From: Simon Davis
Sent: 11 November 2019 10:01
To: [REDACTED]
Subject: AL/81/19/PL - D2, Paddock View

Drawing 2 / 4	
All drawings are copyright of BKM architectural plans and drawings service and may not be reproduced without prior permissions

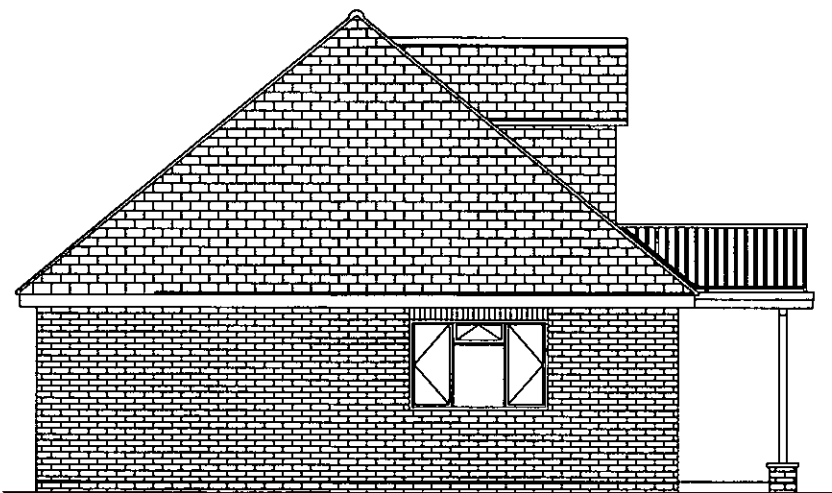
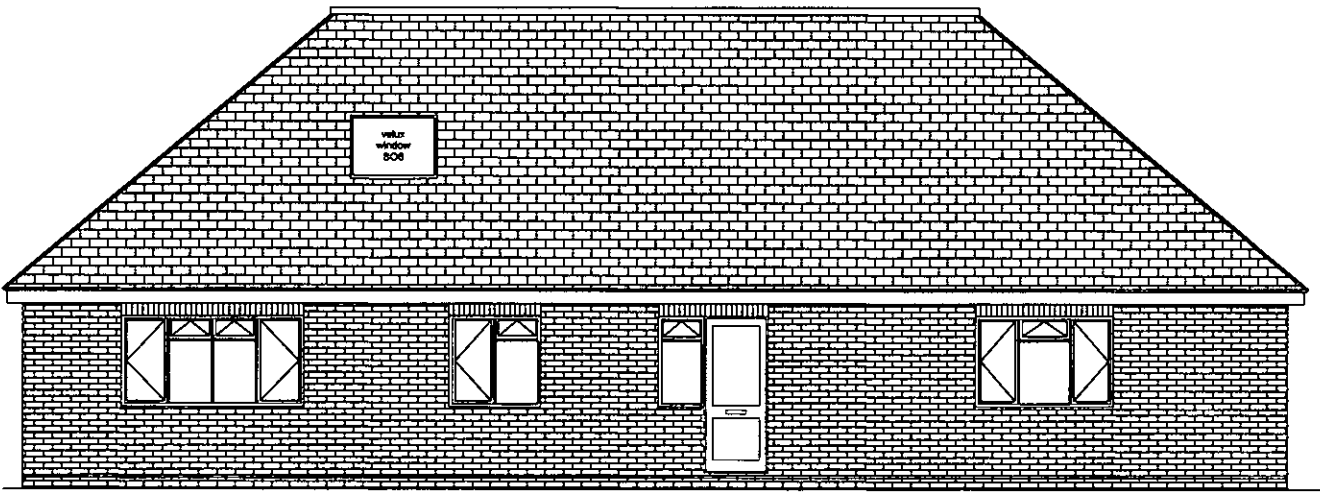
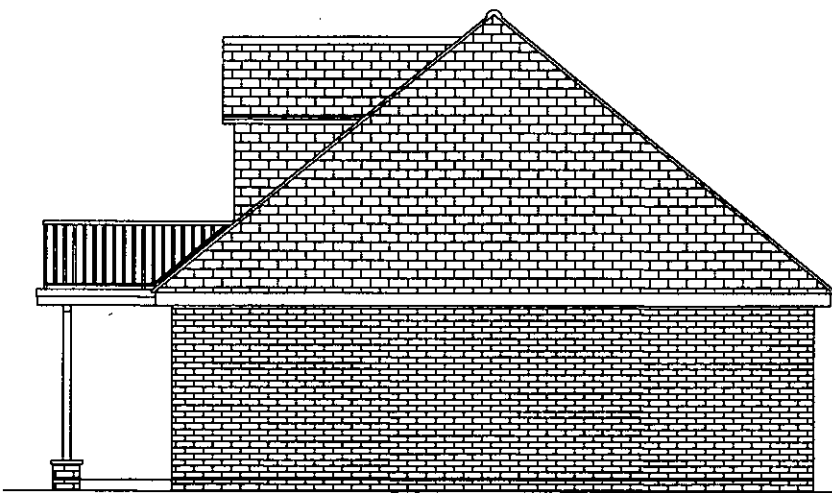
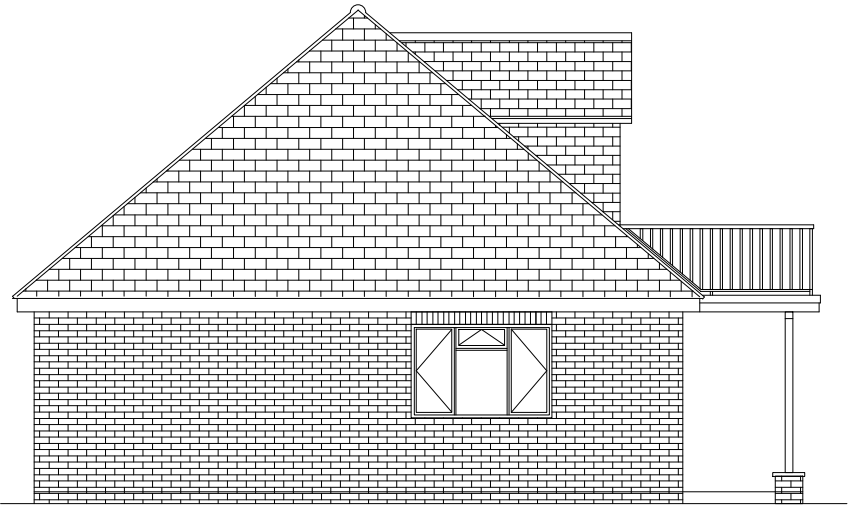
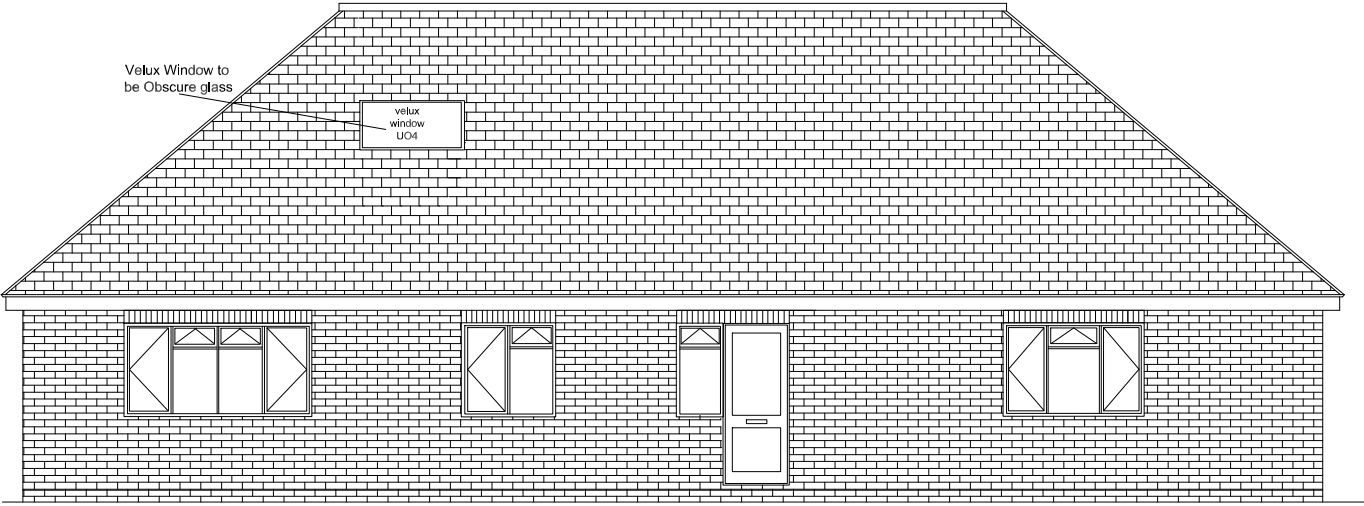
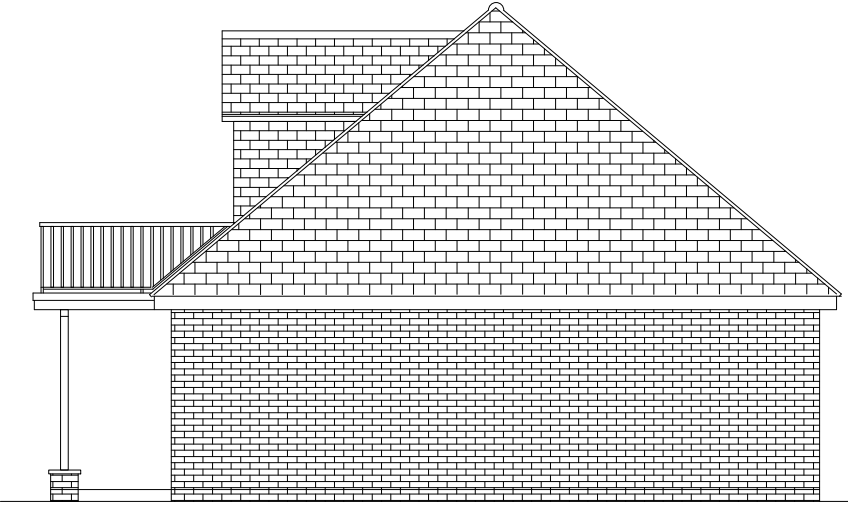
I note on the plans that a velux window is shown in the rear elevation which could potentially permit overlooking of the neighbours property. Is this window strictly necessary?
